Current Zoning: IC-1 (institutional campus) and R-12MF(CD) (multi-family residential, conditional)  
Proposed Zoning: R-12MF(CD) (multi-family residential, conditional) and R-12MF(CD) SPA (multi-family residential, conditional, site plan amendment)

Approximately 3.9 acres located on the north side of Albemarle Road, west of Harrisburg Road, and south of Pence Road.

The petition proposes to allow up to 47 single family attached residential (townhome) units on a vacant parcel located north of Albemarle Road and west of Circumferential Road.

Staff recommends approval of this petition upon resolution of outstanding issues related to transportation, environment, and site and building design.

<p>Issue Date: 12-21-22</p> <p>Project Number: 199.005</p> <p>Sheet 1 of 1</p>	No.	Date	Description	1	3-10-23		2	1-10-23				
No.	Date	Description										
1	3-10-23											
2	1-10-23

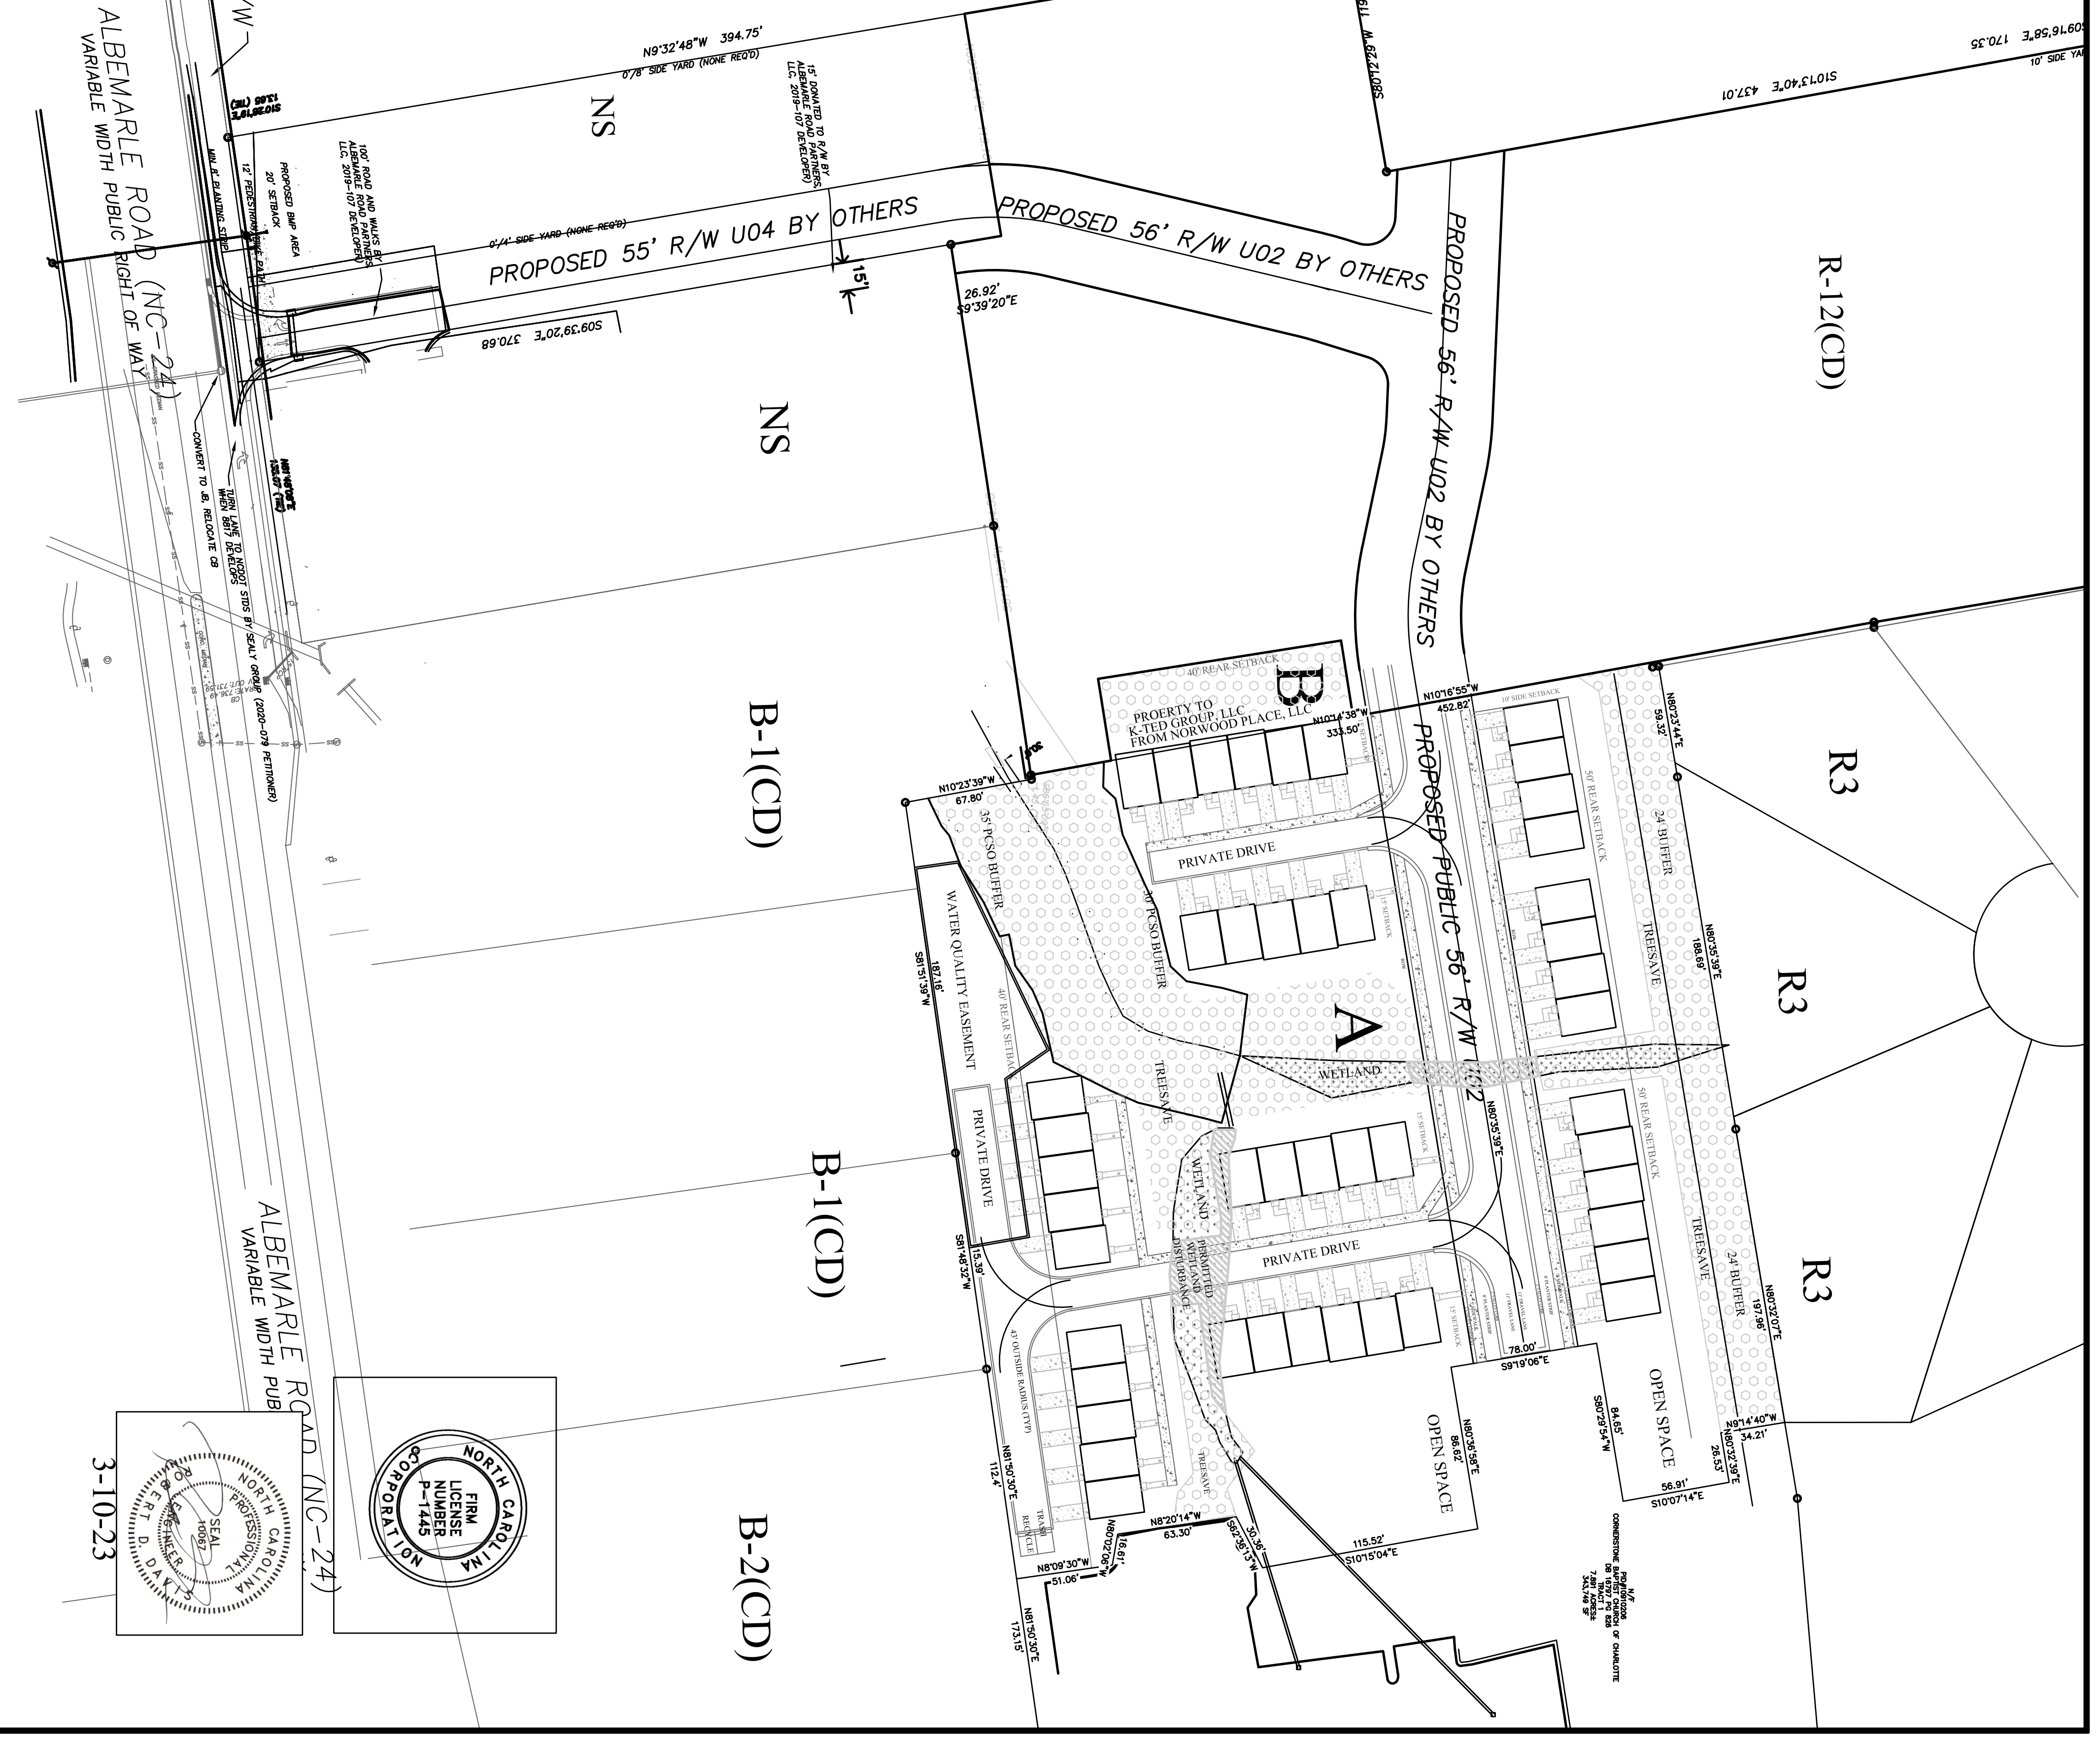
1. Update conditional notes to commit to constructing Dusinane as a U-02 and constructing the 8-foot planting strip and 5-foot sidewalk.
2. Add a conditional note specifying "A Right-of-Way Encroachment Agreement is required for the installation of any non-standard item(s) (irrigation systems, decorative concrete pavement, brick pavers, etc.) within a proposed/existing City-maintained street right-of-way by a private individual, group, business, or homeowner's/business association. An encroachment agreement must be approved by CDOT prior to construction/installation. Contact CDOT for additional information concerning cost, submittal, and liability insurance coverage requirements."

5. Site must show a minimum of 15% of the overall site as tree save.

6. Please provide architectural standards as listed on previous version of site plan.
